SSD 9606 – UNSW D14 ACADEMIC BUILDING – RESPONSE TO SUBMISSIONS REPORT

I am writing to you in reply to your invitation to the Environment Protection Authority (EPA) to comment on the Response to Submissions (RtS) report concerning the above project.

Figure 2 | Purple line: EIS site boundary

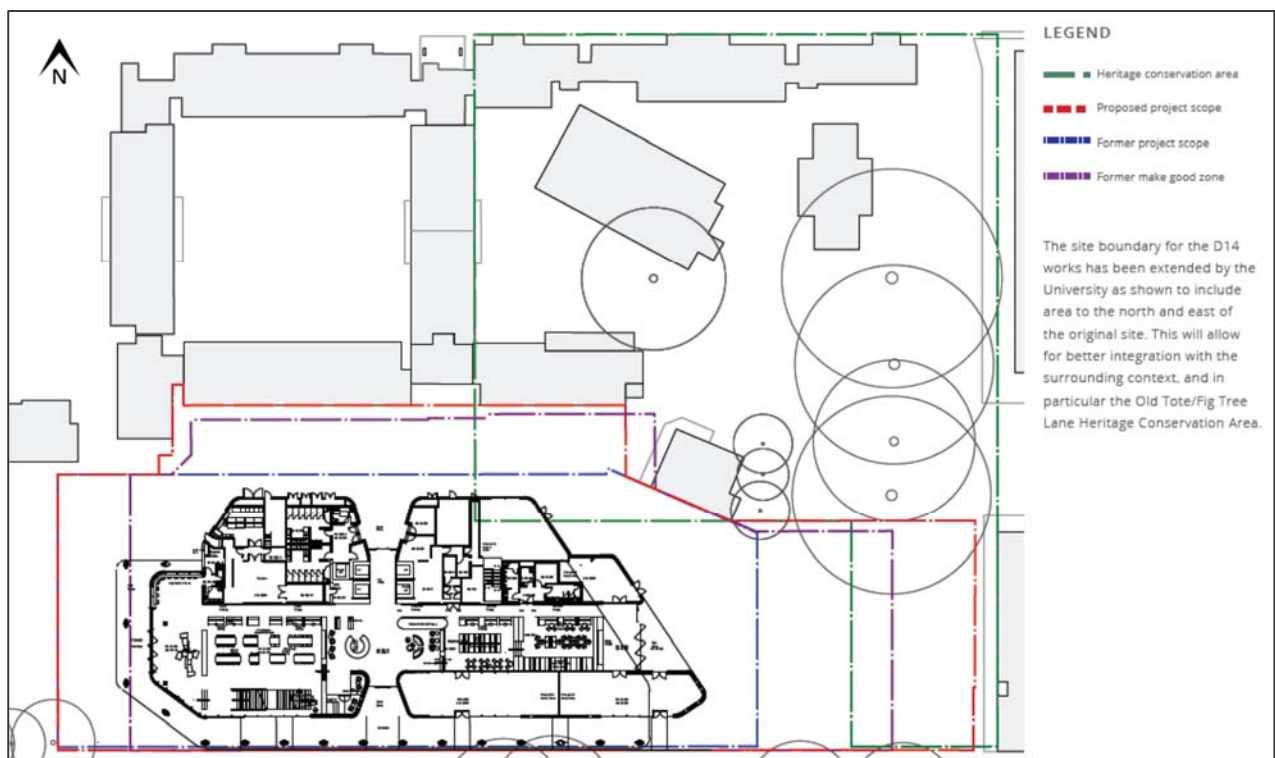
- b. Based on the original remediation action plan, the site is part of Lot 3 in Deposited Plan 1104617 with an area of approximately 5,200m². Soil samples were collected from 6 boreholes for 5,200m² area. As per Appendix K, the boundary of the proposed work expanded by 1,200m², hence the total area is about 6,400m². The EPA notes that the recommended minimum number of sampling points specified in the Sampling Design Guidelines (NSW EPA, 1995), is 13 for 5,000m² and 17 for 7,000m².

- c. The consultant commented that "the data gap assessment will include a further 9 test locations such that the eventual sampling plan will exceed the minimum recommended in the Sampling Design Guidelines." The EPA disagrees with this comment. The proposed number of additional samples is still not sufficient due to increased area totalling 6,400m². The EPA recommends additional 11 sampling locations (instead of just 9) during the proposed additional investigation to help meet the minimum number of samples for an area of approximately 6,400m².

1. Increase the proposed number of sampling locations (from 9 locations to 11 locations) to accommodate the increase in boundary area of this proposed development.
